**Response to the Non-Statutory Consultation on Proposed Changes to the Application by Medworth CHP Limited for an Order Granting Development Consent (DCO) for the Medworth Energy from Waste (EfW) Combined Heat and Power (CHP) Facility**

We are writing on behalf of Cambridgeshire County Council (CCC) and Fenland District Council (the Councils) in response to the non-statutory consultation on Proposed Changes to Medworth CHP Limited's (the Applicant's) application for a DCO to construct, operate and maintain an EfW CHP Facility on the industrial estate at Algores Way, Wisbech, Cambridgeshire.

March 2023

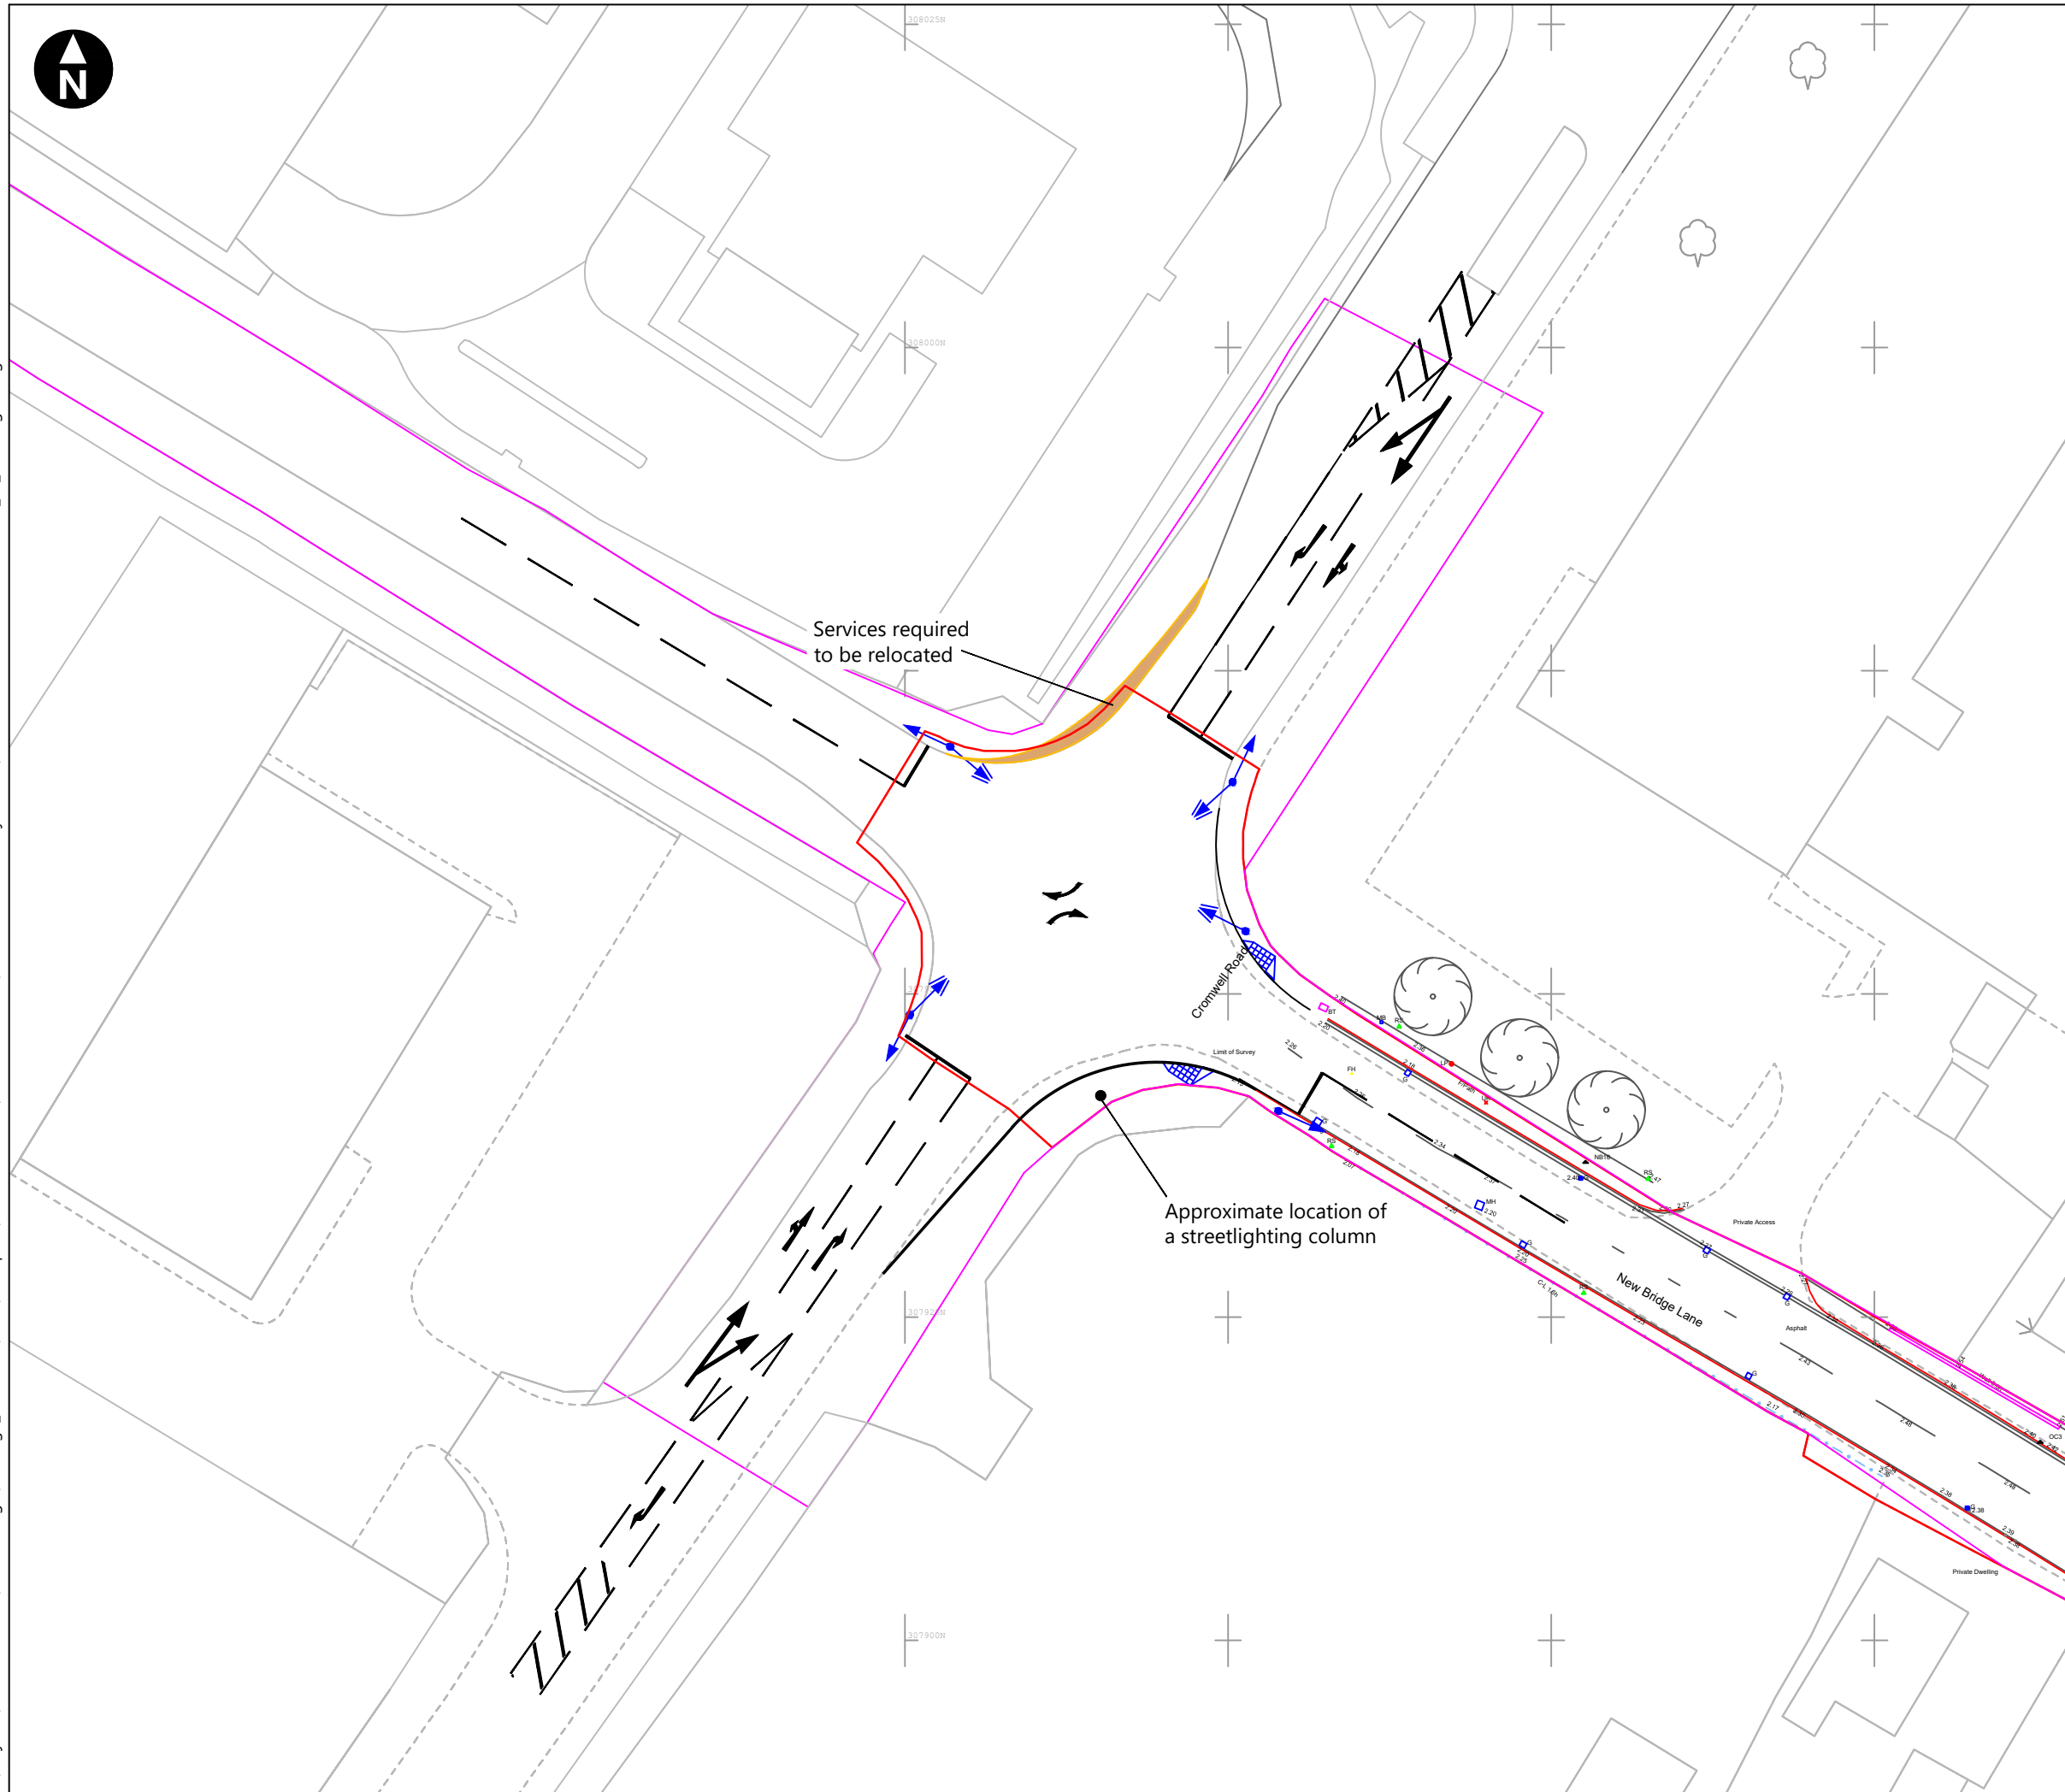
- As raised by CCC at ISH6 on 26<sup>th</sup> June 2023, the Councils question whether the Proposed Changes adequately extend the DCO boundary, and whether sufficient powers of compulsory acquisition are included to ensure that the revised junction layout at New Bridge Lane/Cromwell Road can be delivered within the Order limits and subsequently (where appropriate) dedicated as highway. CCC continues to engage with the Applicant in respect of the junction design to achieve clarity on this matter.

- The Councils acknowledge that the Applicant is now proposing to modify the original design to construct central traffic islands, allowing the safe signal control of right turning vehicles from Cromwell Road towards the development. CCC notes that the provided 'Linsig' traffic modelling does not represent the traffic signal
